SSD 10375 (Pitt St North) Stage 2 Development Application – Advice on EIS

Thank you for your correspondence dated 16 July 2020 seeking the City of Sydney's (the 'City's') comments on the above detailed design for the Pitt Street North OSD at 175-183 Castlereagh St, Sydney.

3.2 level 10 - detail plan - 1/2

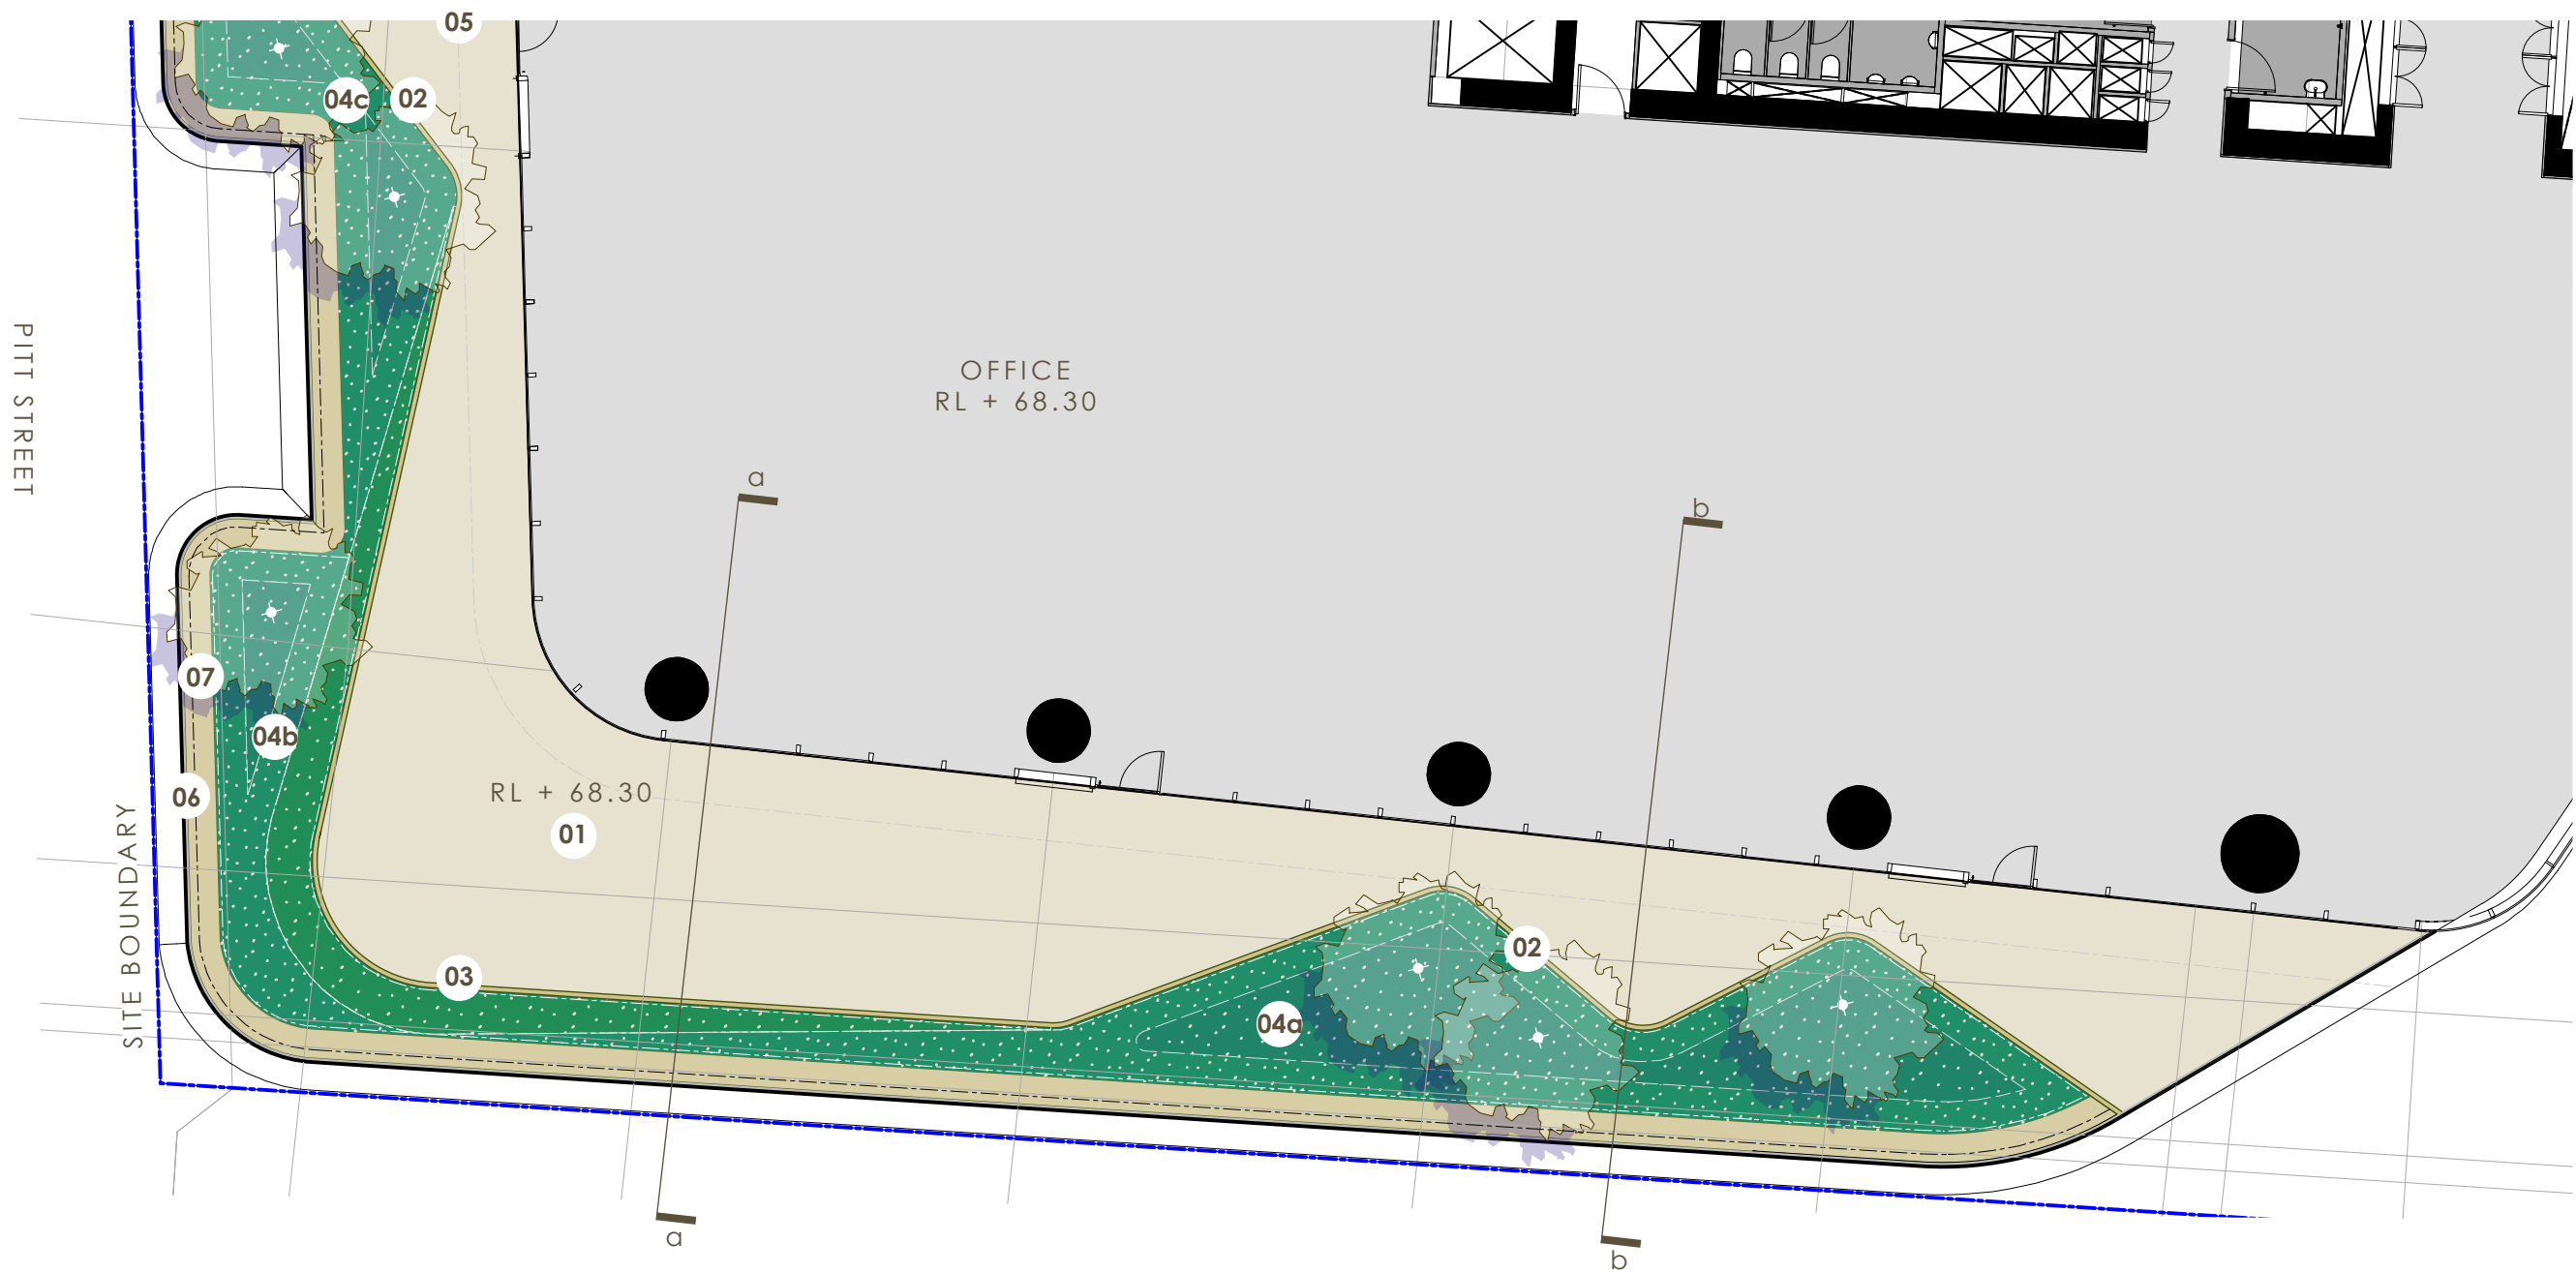
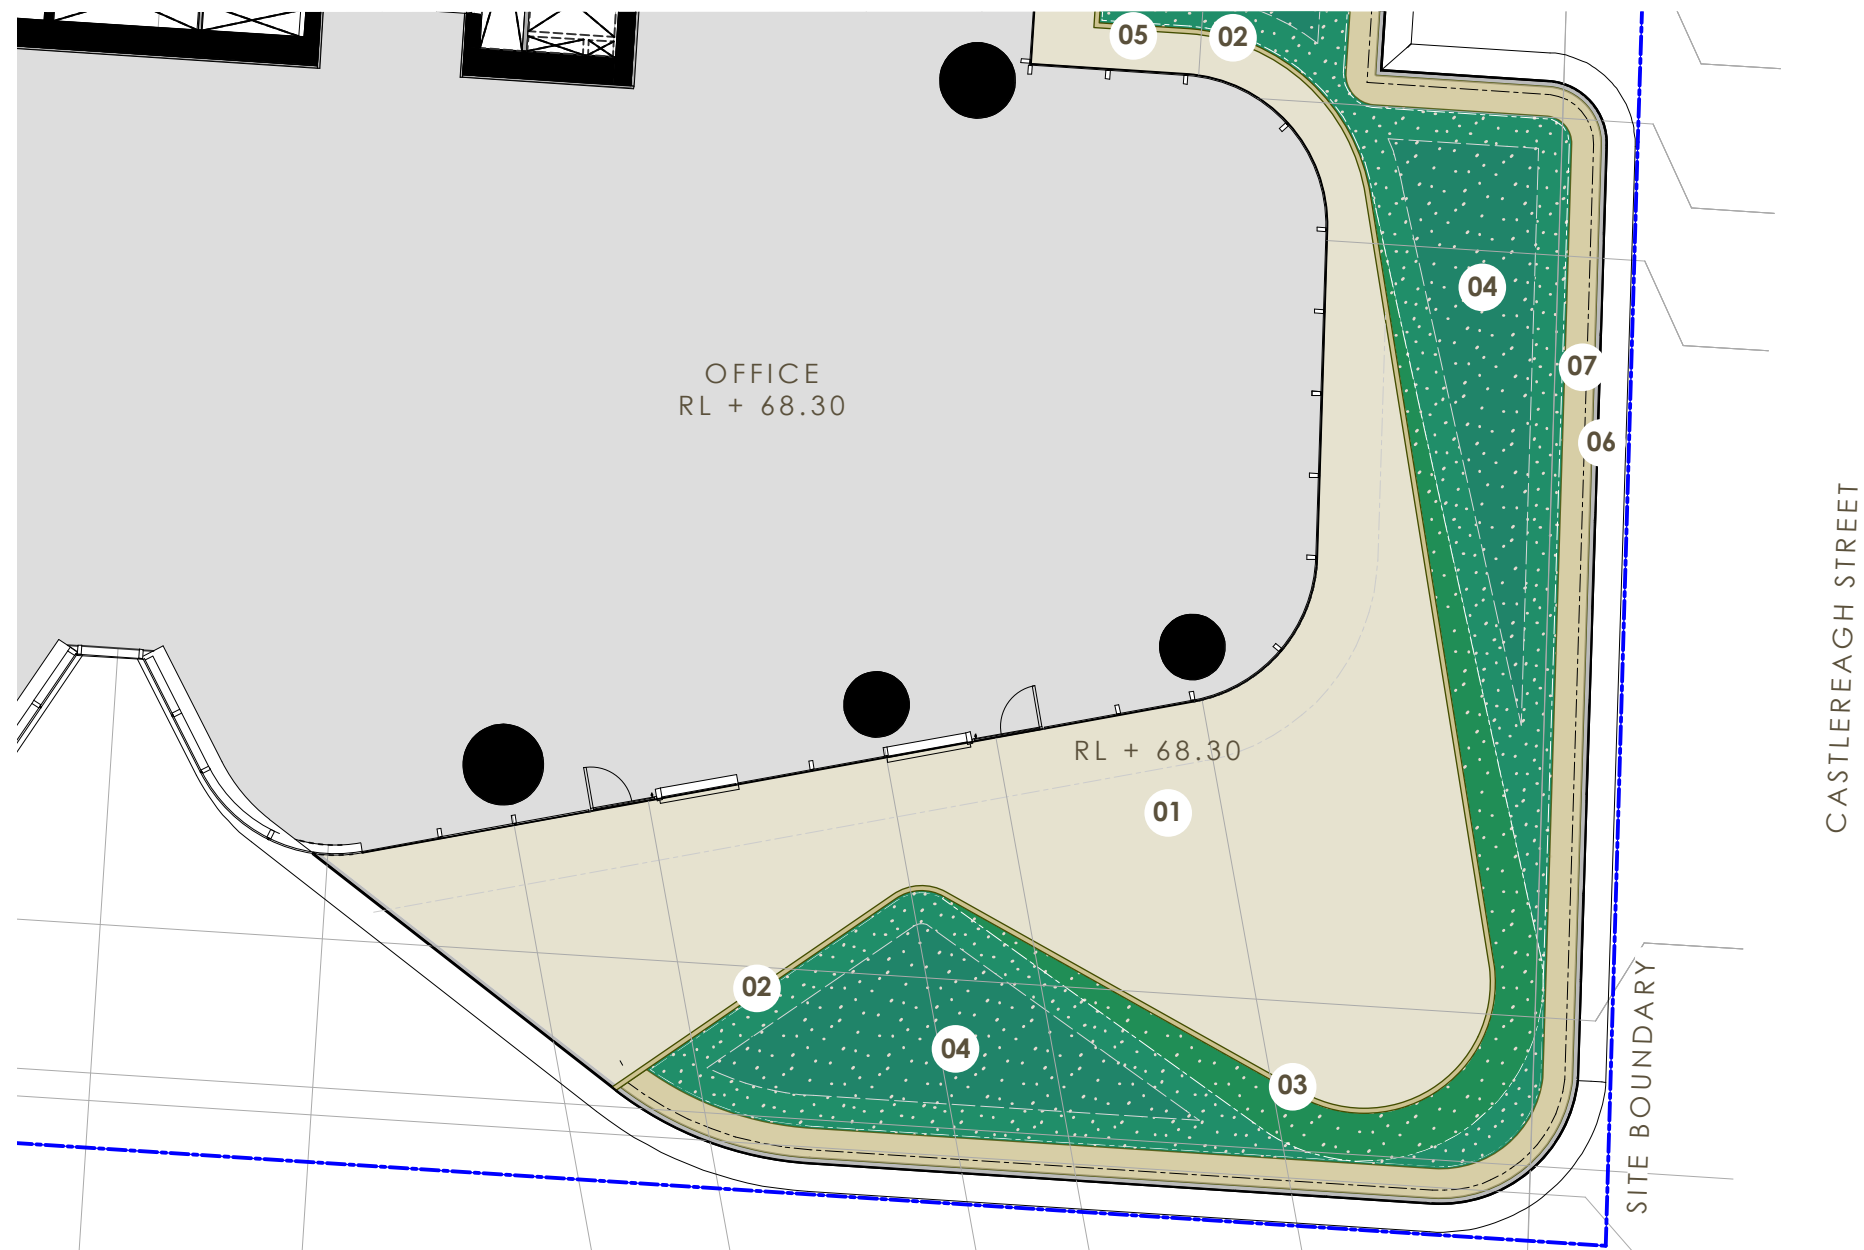
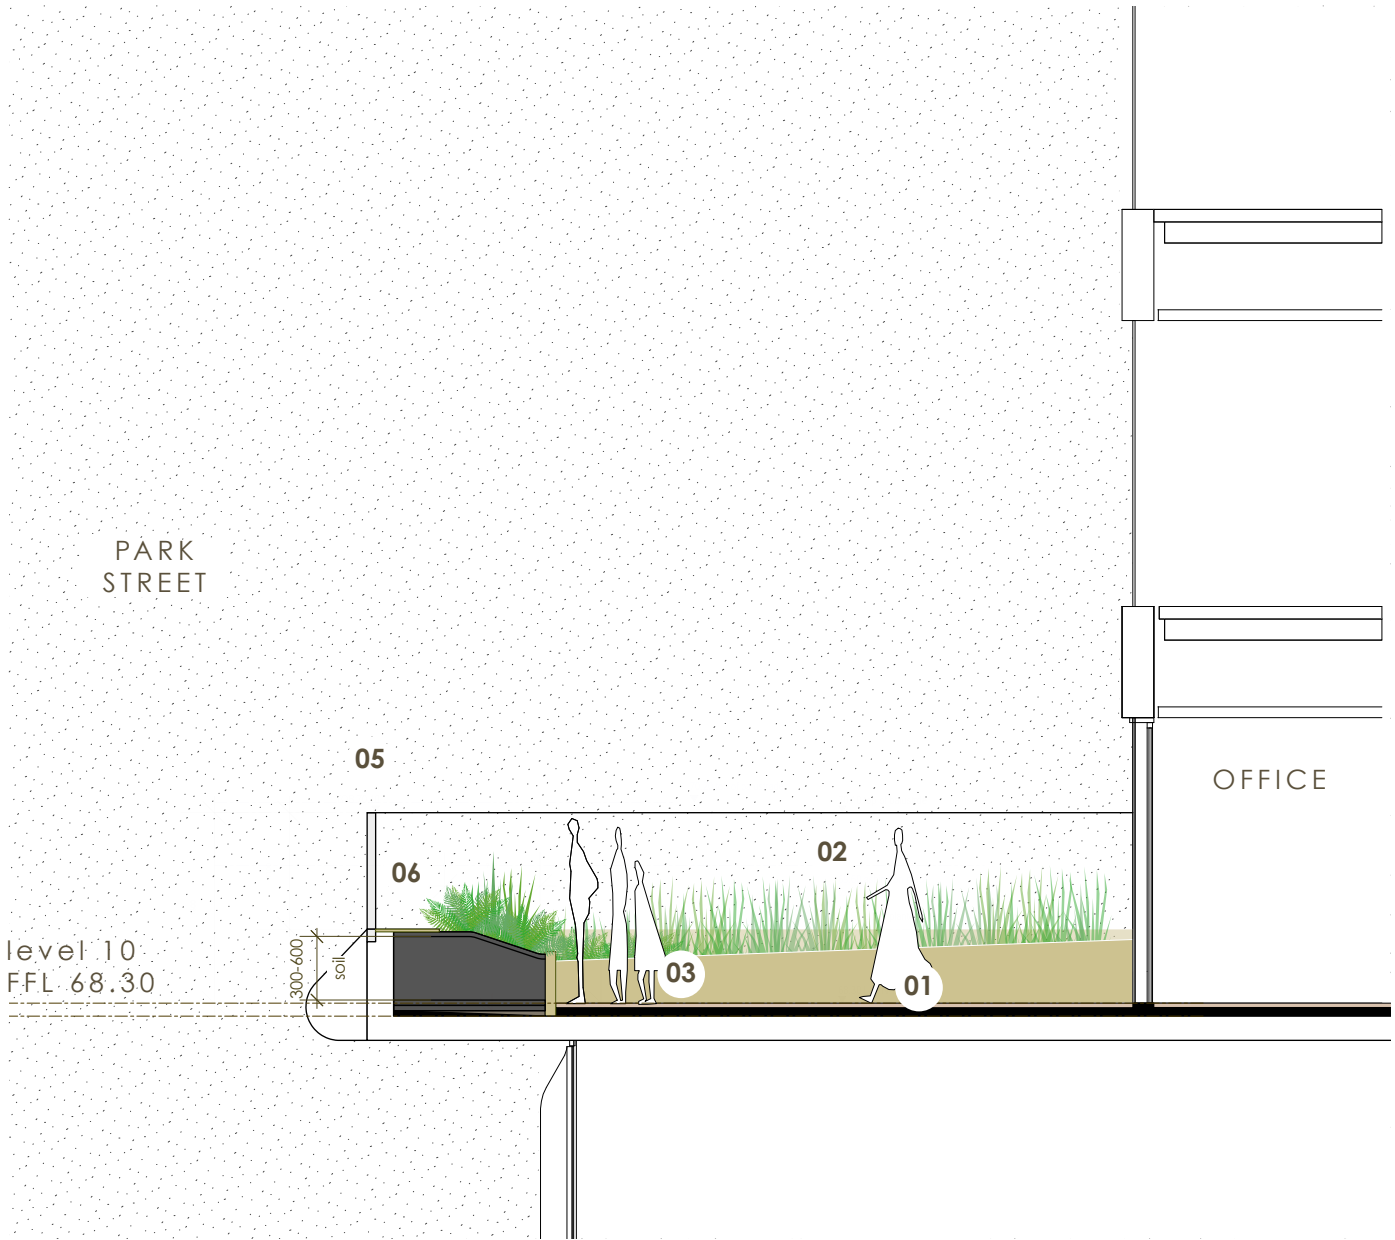
- (ii) Submit amended plans coordinated with wind recommendations;
 - (iii) Amend Level 10-11 tree planters to provide minimum 1metre soil depth and comply with the *Sydney Landscape Code Volume 2*;

- (iv) Substitute small with a mix of medium sized tree species and add additional trees to meet the wind report recommendations on both levels;
 - (v) Submit details for climbing frame and planter for green screens to service areas.
